The Planning Inspectorate

M4 Junctions 3 to 12 Smart Motorway

The Examining Authority's second written questions and requests for information

Issued on 11 December 2015

Figure 14.1: Construction Compound 5 1 in 100 year plus climate change floodplain.

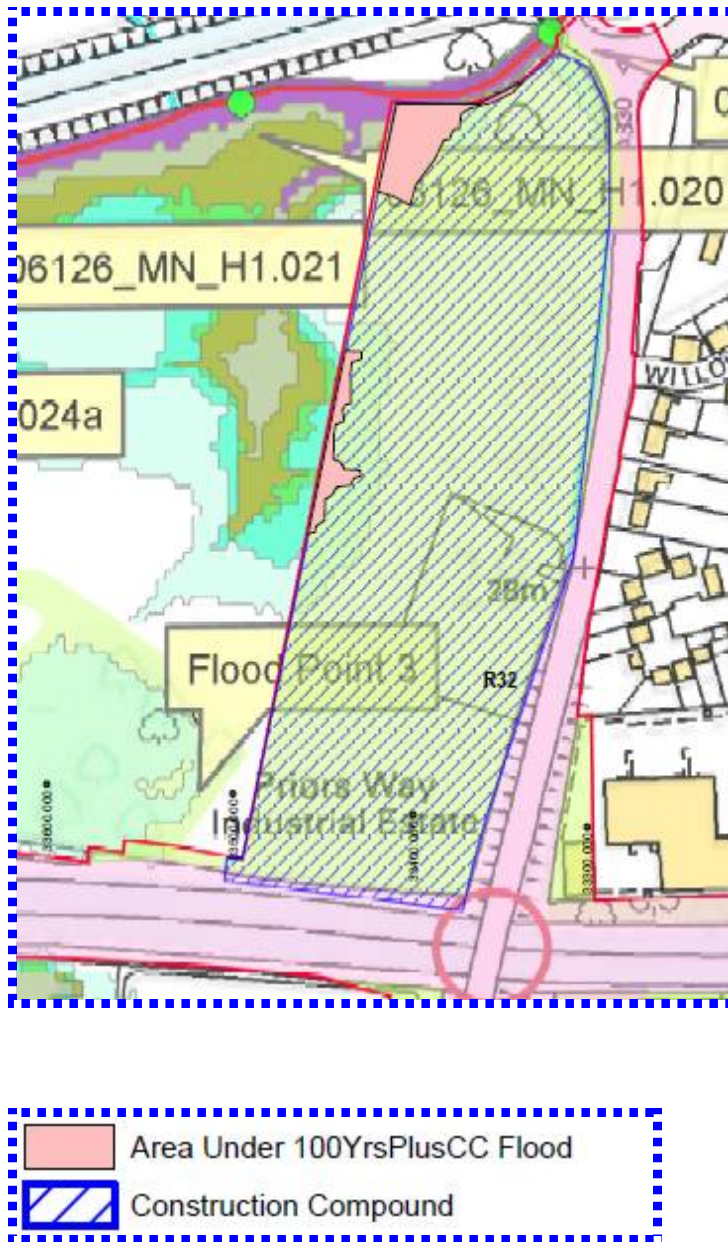
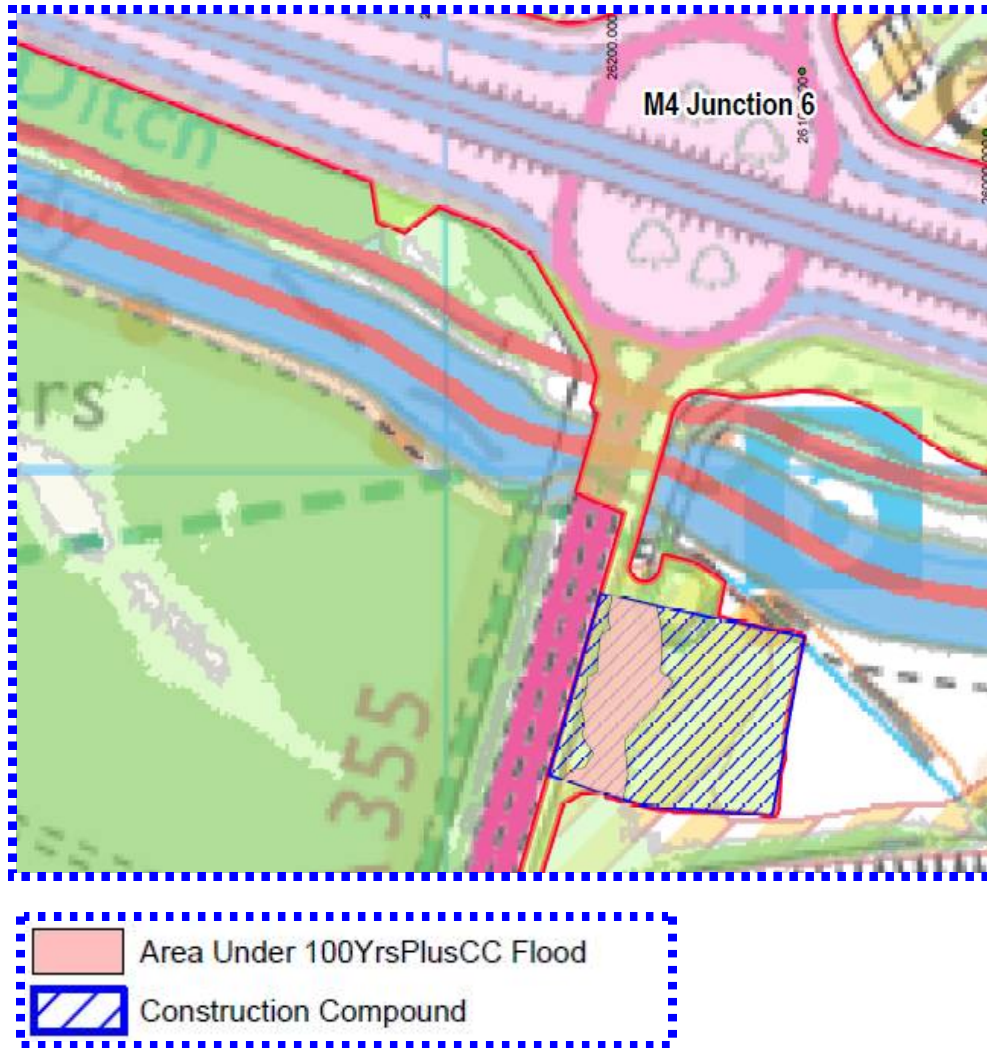
- iv. The EA has requested confirmation if flood compensation is required for any of the work compound areas (particularly work Compound 5) and to confirm the precise number of locations where flood compensation is required.
